Two storey extension to front elevation, new verandah & relocation of front door, raise rear pitch roof, extend garage with pitch roof & remodel existing dormers with pitch roofs.

4 Apple Grove Aldwick

Thank you for your internet representation made on 7th November 2017 which has been recorded as '**an objection**' with the comments as follows:

Title
Plans as Proposed

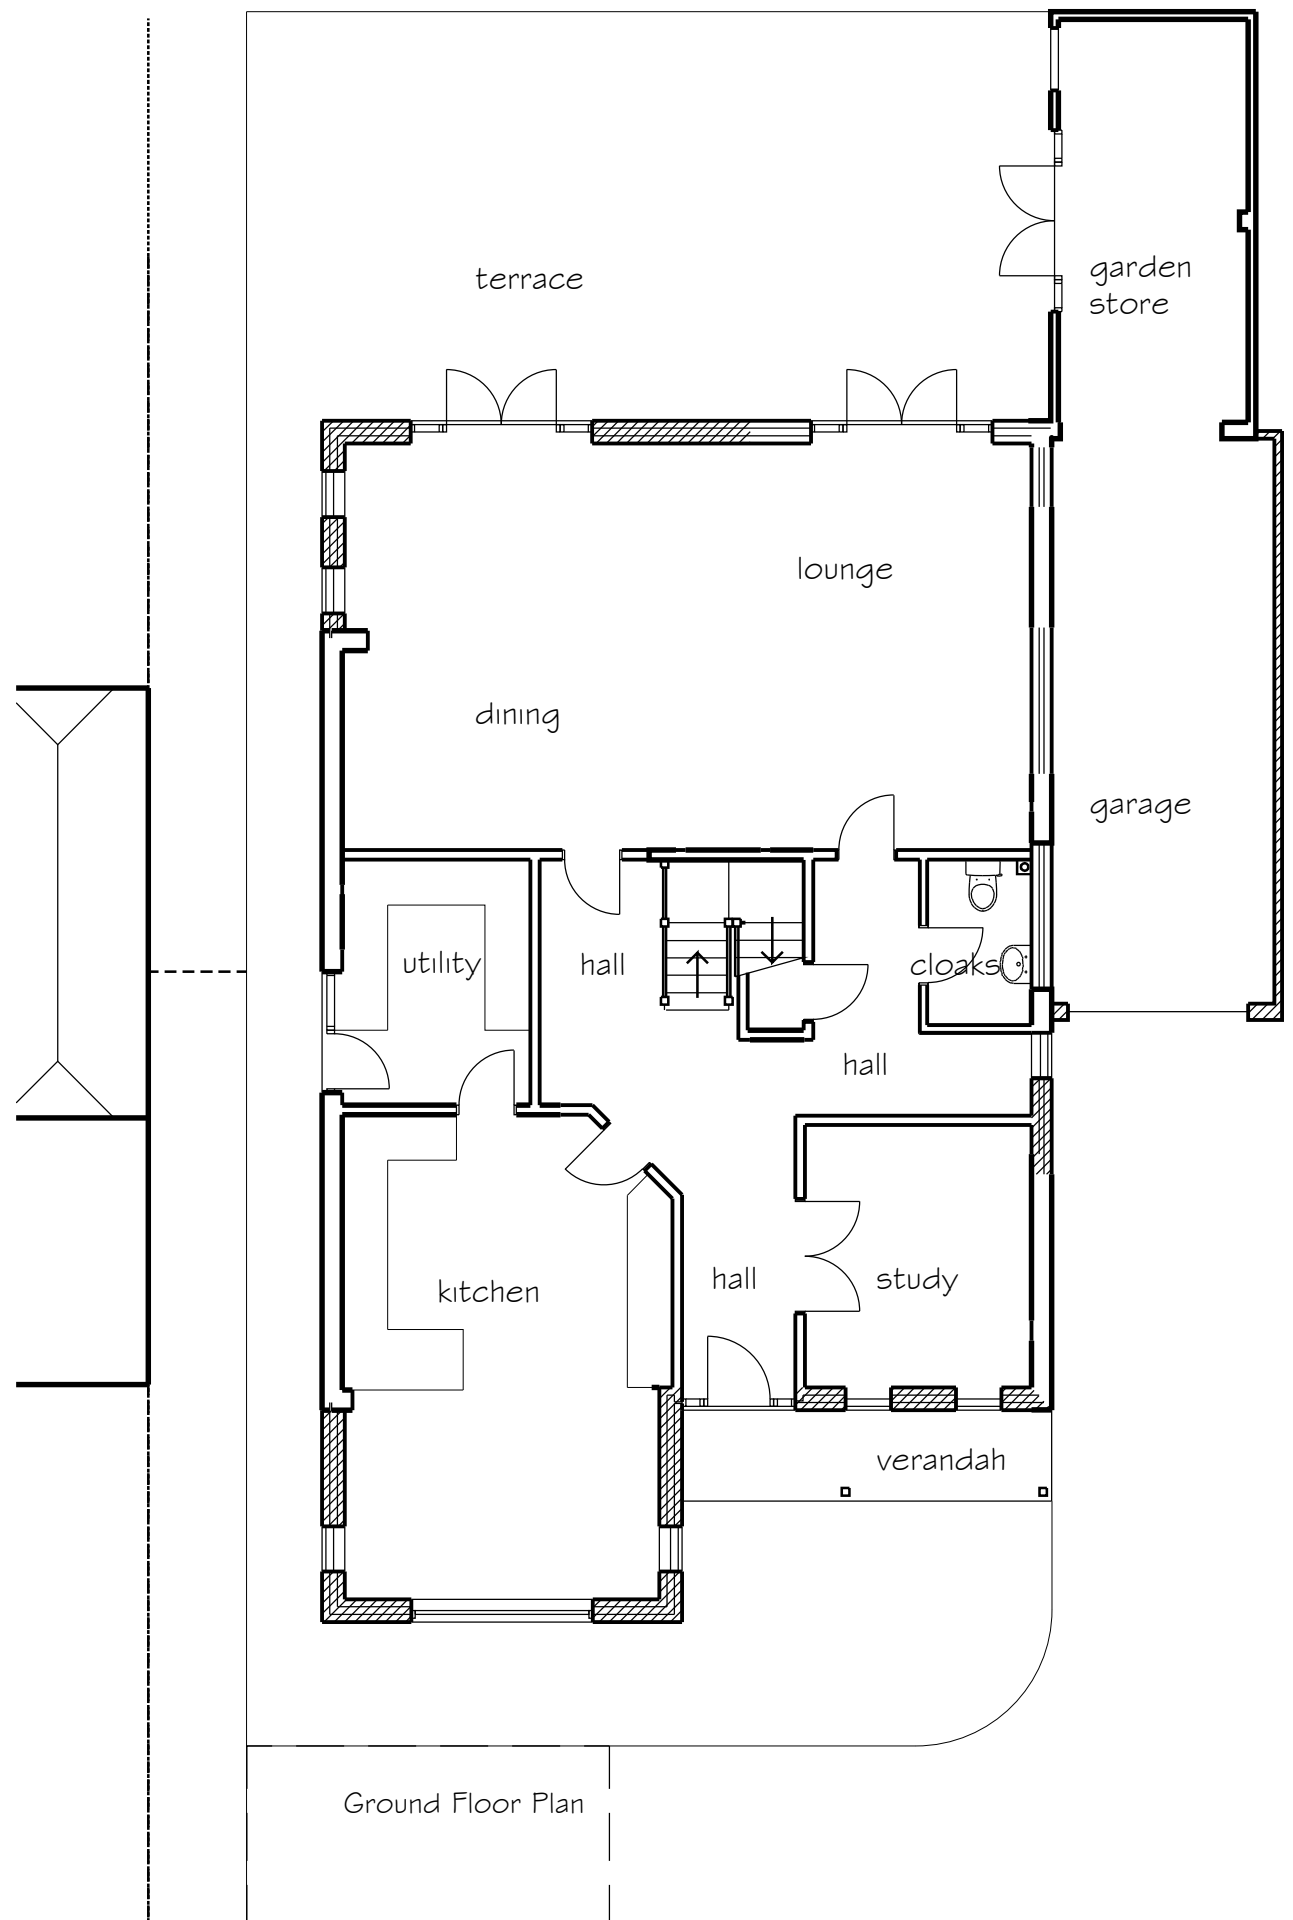
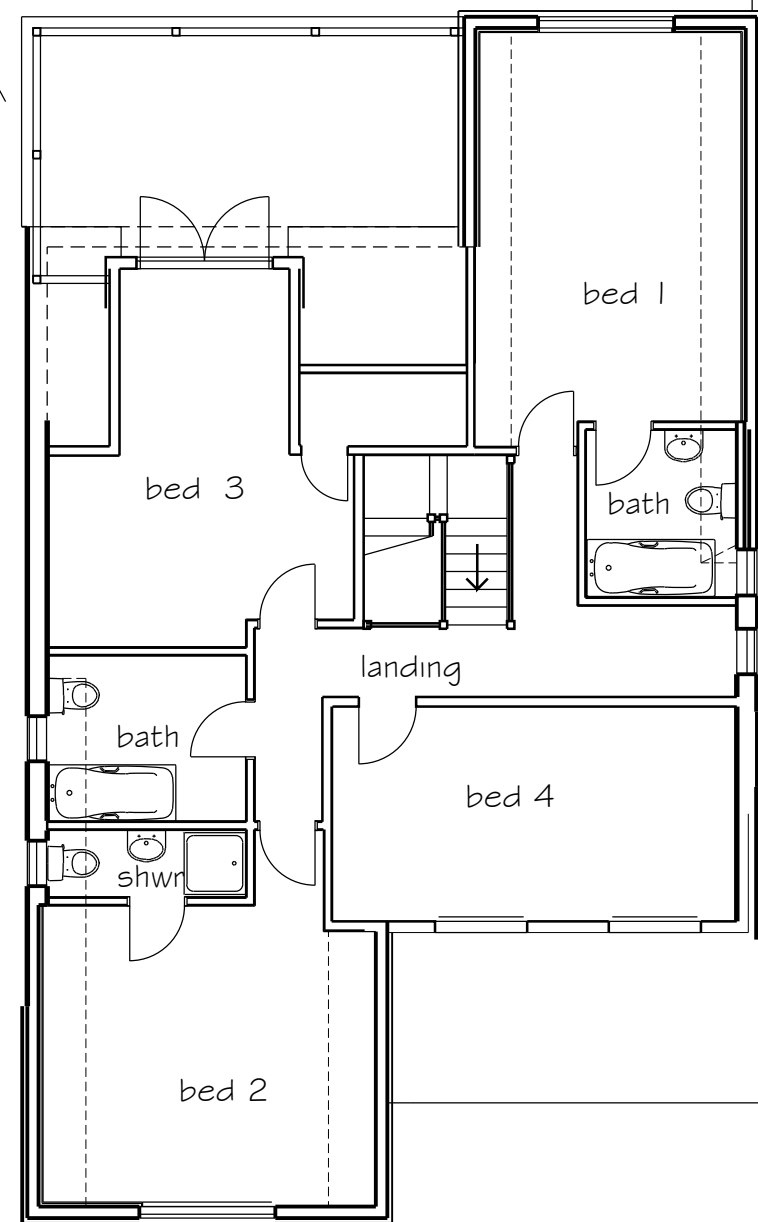
2 The proposed front extension would, we believe, materially alter the street scene and line of the houses as they've been built. On August 2 2012 the council refused application reference AW/134/12/ for the adjacent property, which is of the same design, for the following reason:

If a flat roof dormer extending the existing flat room dormer and remaining within the footprint of the original house was deemed to be too large and detrimental to the street scene, then surely a two storey extension with pitch roof projecting well beyond the original footprint of the property, in addition to pitch roofs on the existing front dormer, must be considered to be too large and out of keeping with the street scene.
